# CITY OF ALBUQUERQUE

**Re: Cactus Patch Plaza – 7801 La Morada Pl. NW  
Erosion and Sediment Control Plan  
Engineer's Stamp Date 7/29/2021 (H10E034)**

TEMPORARY EROSION AND SEDIMENT CONTROL PLAN

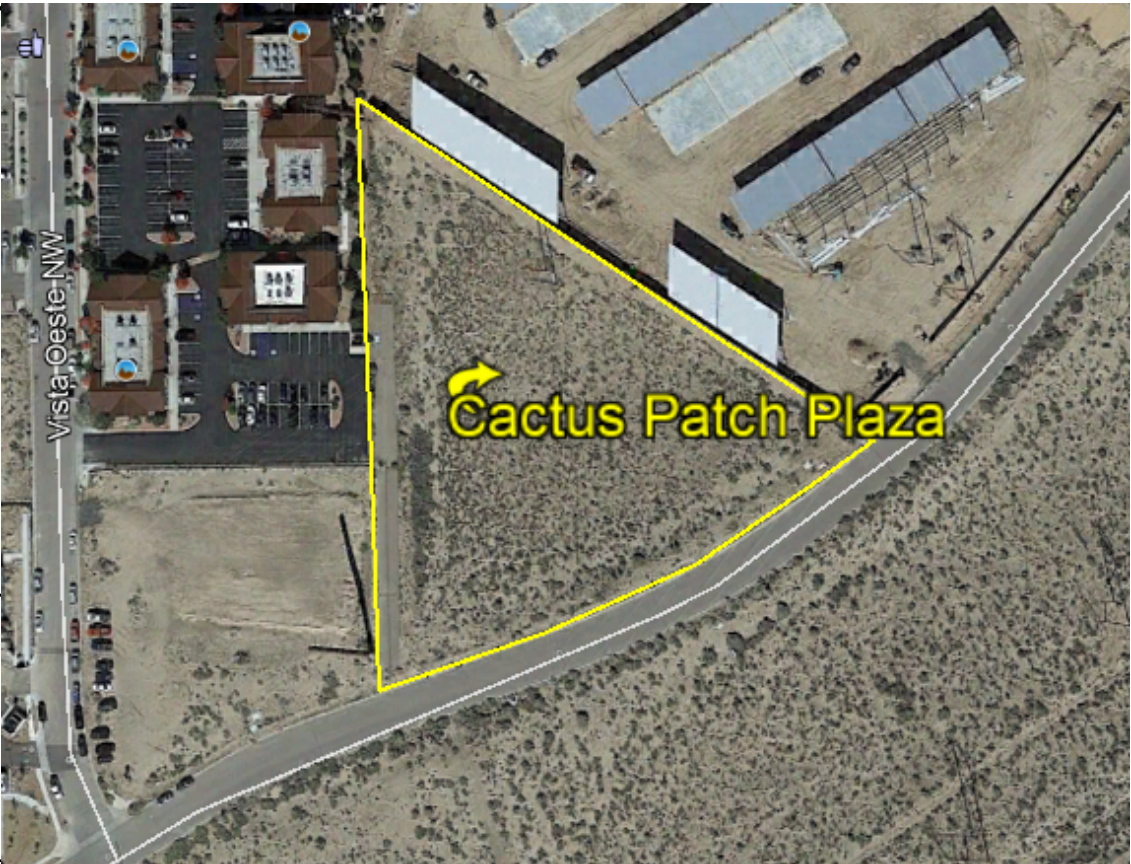
The ESC Plan can't be approved for Grading, Building Permit, or Work Order until the Grading and Drainage Plan is approved by hydrology for each of those purposes. An individual plan may be provided for each goal. The existing and proposed grades must be shown on the plan, and they must agree with the Grading Plan approved by Hydrology (CGP7.2.4.b.ii)
